HAY CREEK VALLEY

EL PASO COUNTY, COLORADO

FINAL GRADING & EROSION CONTROL PLANS

DECEMBER 2023

GRADING & EROSION CONTROL PLAN

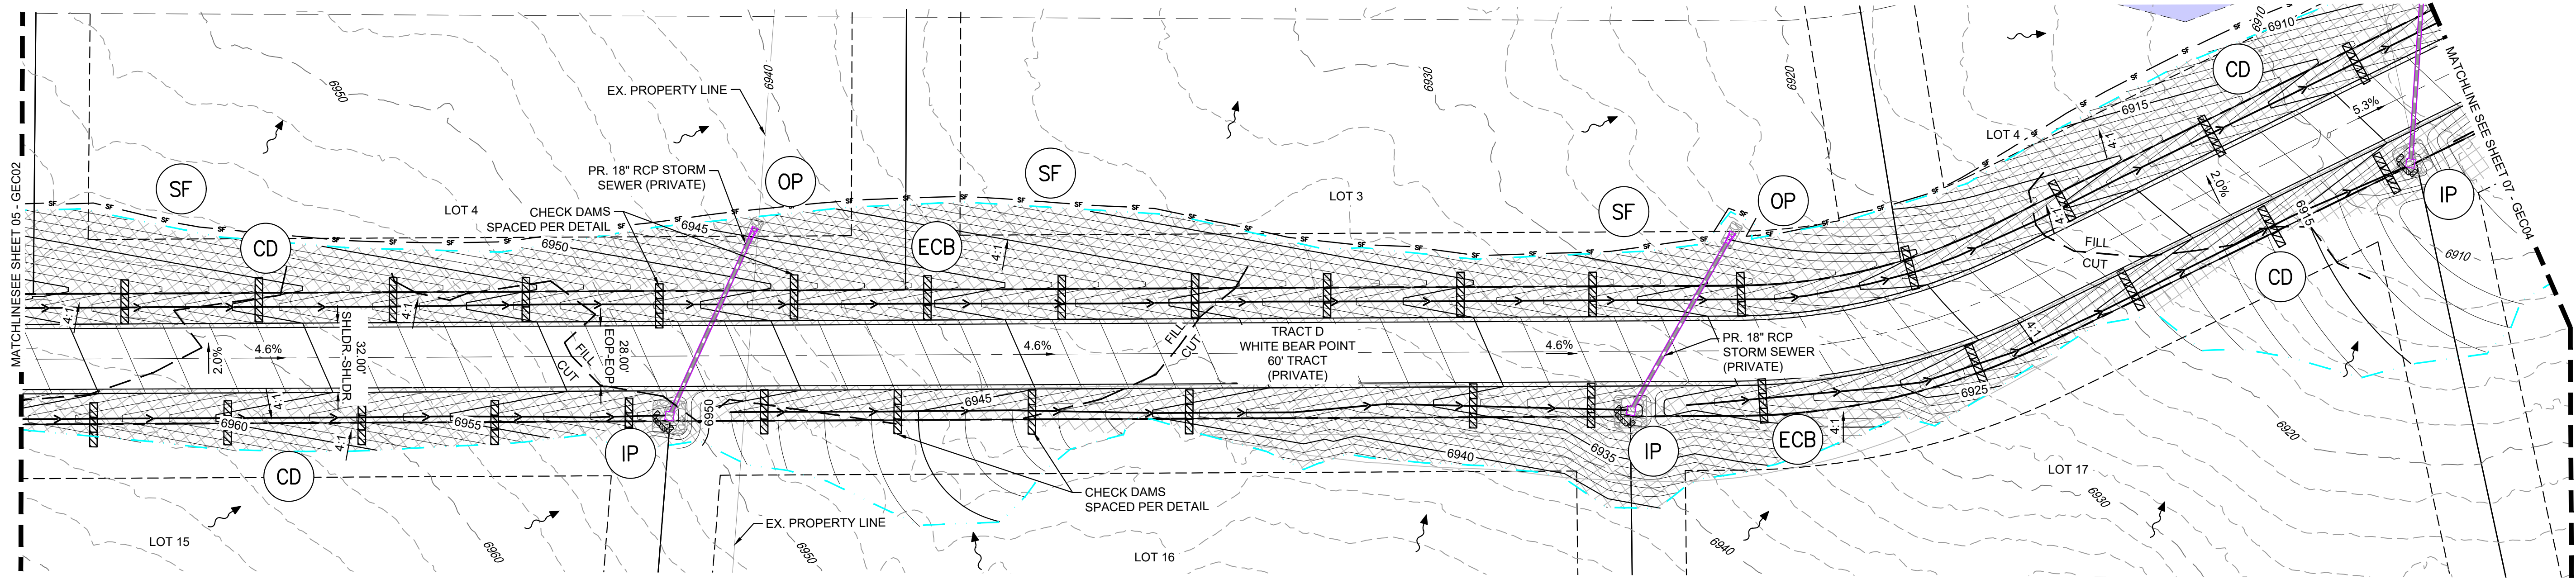
SILT FENCE SHOULD BE PARALLEL TO CONTOURS. PLACEMENT AS SHOWN COULD CHANNELIZE RUNOFF. ALL SILT FENCE NOT RUNNING PARALLEL TO CONTOURS SHALL BE INSTALLED WITH J-HOOKS OR ADJUSTED AS NECESSARY.

Why no PS/MU in roadside areas in addition to the ECB which is shown?
